**SEAS DEADLINE 6 RESPONSE to APPLICANTS's SUBMISSIONS**  
**SINCE DEADLINE 5, ISH3, Action Points and ExQ3**  
**LANDSCAPE & VISUAL and CULTURAL HERITAGE**

**PINS Ref:** EN020026  
**DEADLINE 6:** APRIL 13, 2026

**RE: SEAS Response to Applicant's Submissions since Deadline 5, ISH3, Action Points and ExQ3 – Landscape & Visual and Cultural Heritage**

# EN020026 SEA LINK DCO – DL6: RESPONSE BY NICHOLAS BRIDGES

Figure 1. EN010077-001489-6.2.29.7 EAIN ES Figure 29.7 Onshore Substation ZTV (with landscape character)

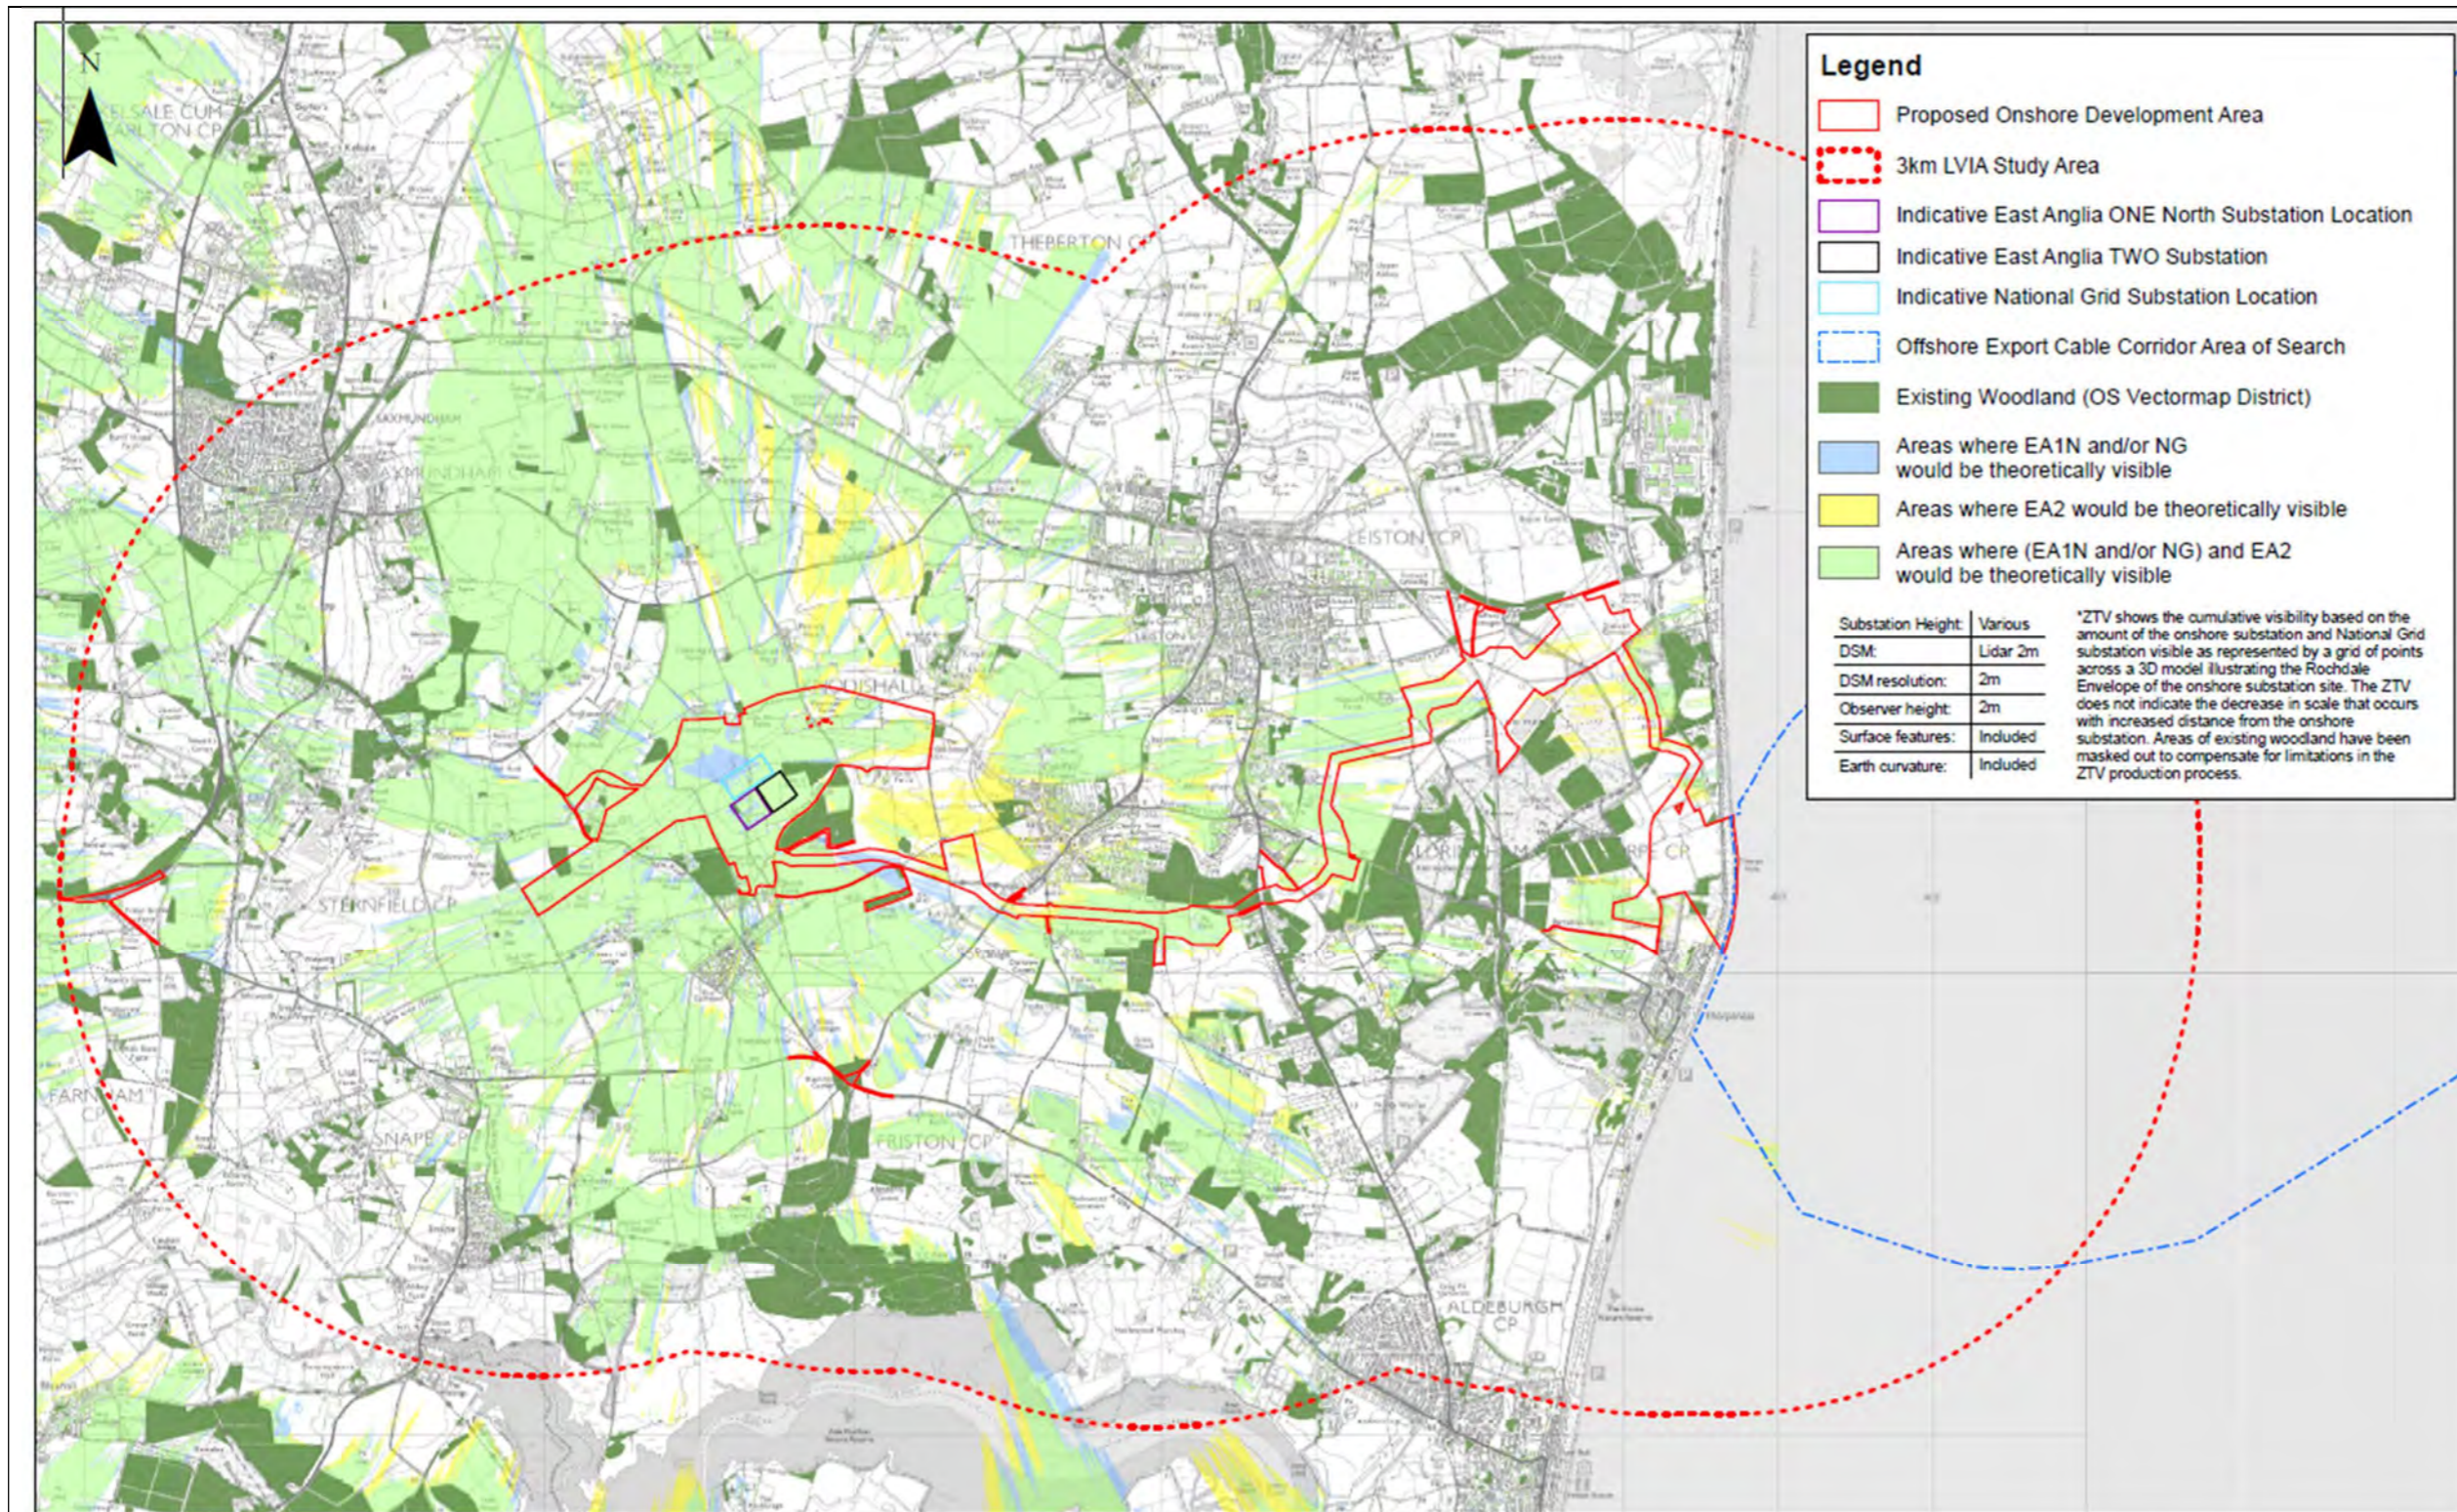
2.9. The ZTVs of the two Friston projects and Sea Link's PEIR have a similar pattern of visibility around their projects (see **Figures 1 to 11** below). Sea Link includes the National Grid substation at Friston which each of EA1N and EA2 also included. All Projects were modelled using OS contours, woodland and buildings at a generic height. Observer heights were a little higher for EA1N and EA2. The two Friston substations used the same parameter model as Sea Link.

2.17. The applicant does not seem aware of the EA1N and EA2 ZTV plans (**Figures 1, 2 and 3** below) which show that those developments would be visible. Nor the Sea Link PEIR likewise. Visibility from the top of the church tower is not relevant as the public have no access nor is it important as a private viewing point, unlike the Martello Tower for which this use was its primary function.

Figure 6. Sea Link 2023-10 PEIR Volume 3 Part 2 Chapter 2 Figures A, page 8:
 REPRESENTATIVE VIEWPOINT LOCATIONS AND SCREENED ZONE OF THEORETICAL VISIBILITY - PROPOSED SAXMUNDHAM CONVERTER STATION AND SPR FRISTON SUBSTATION (OPTION 1)

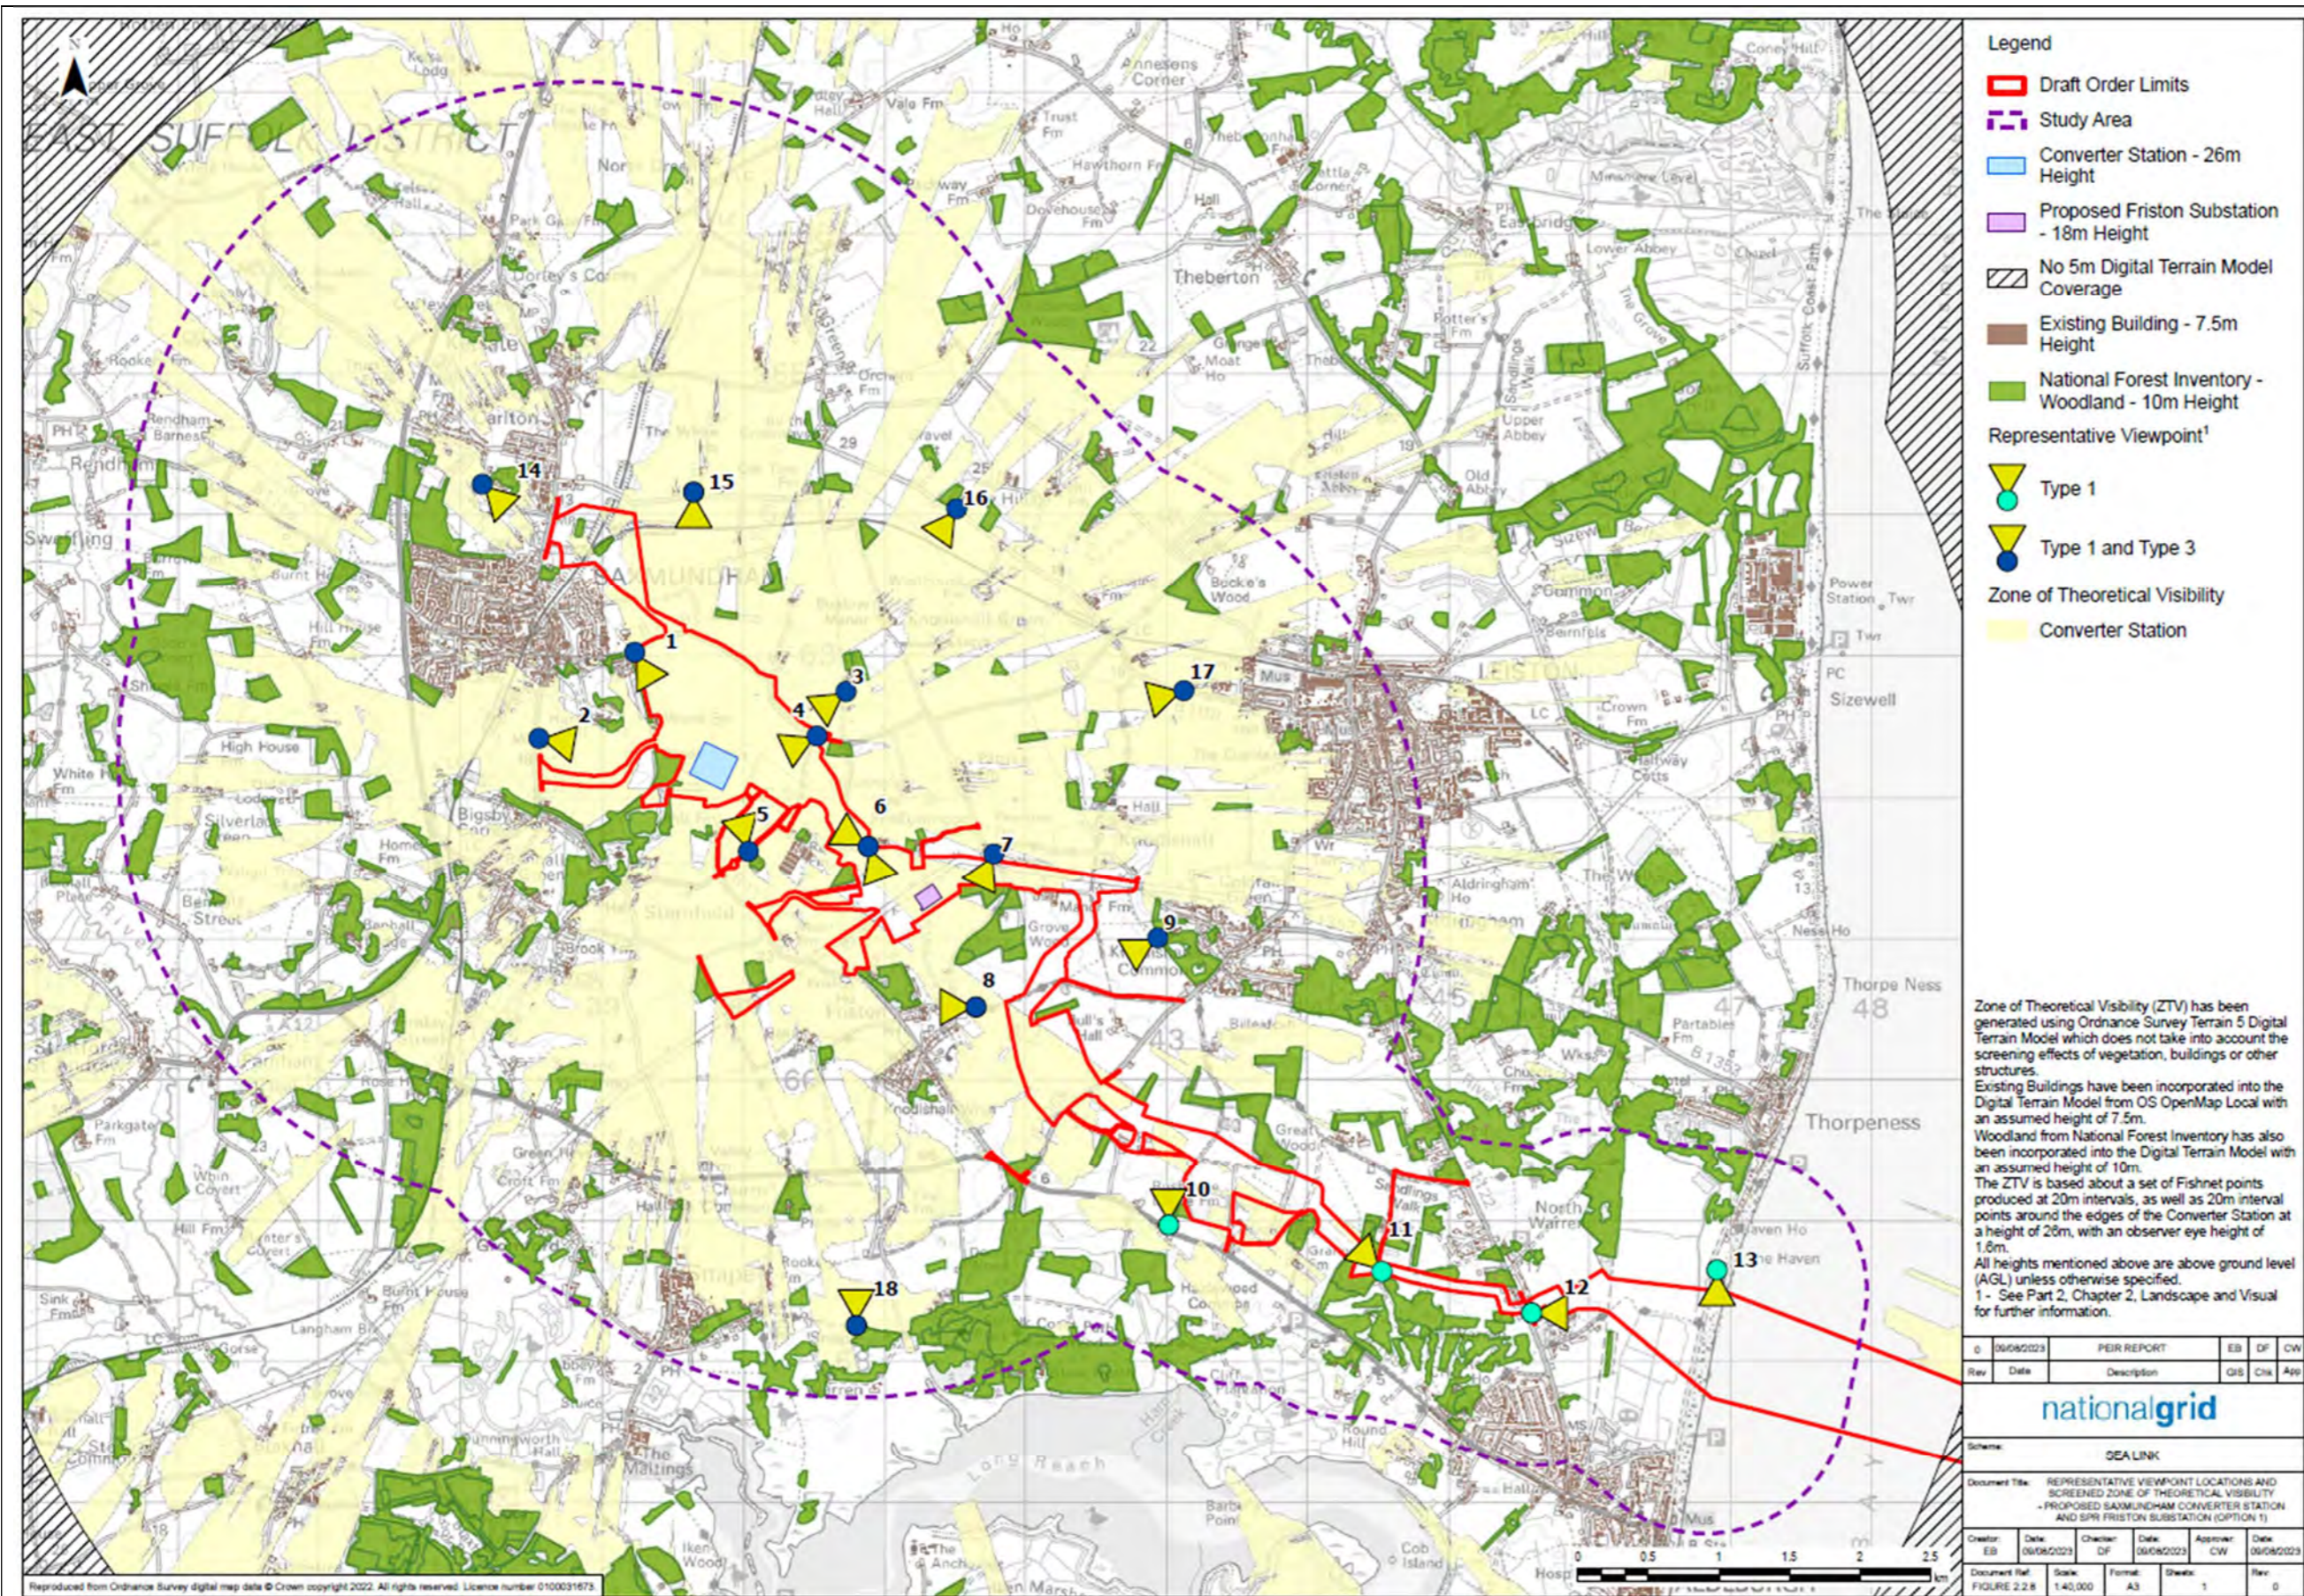
2.11. The **first question** is: why are the PEIR and DCO plans so completely different? Were the heights in the model changed? Were the shadowing criteria altered? Which is correct? If the DCO is correct, were the EA1N and EA2 ZTVs incorrect? These are simple technical points which can be explained easily.
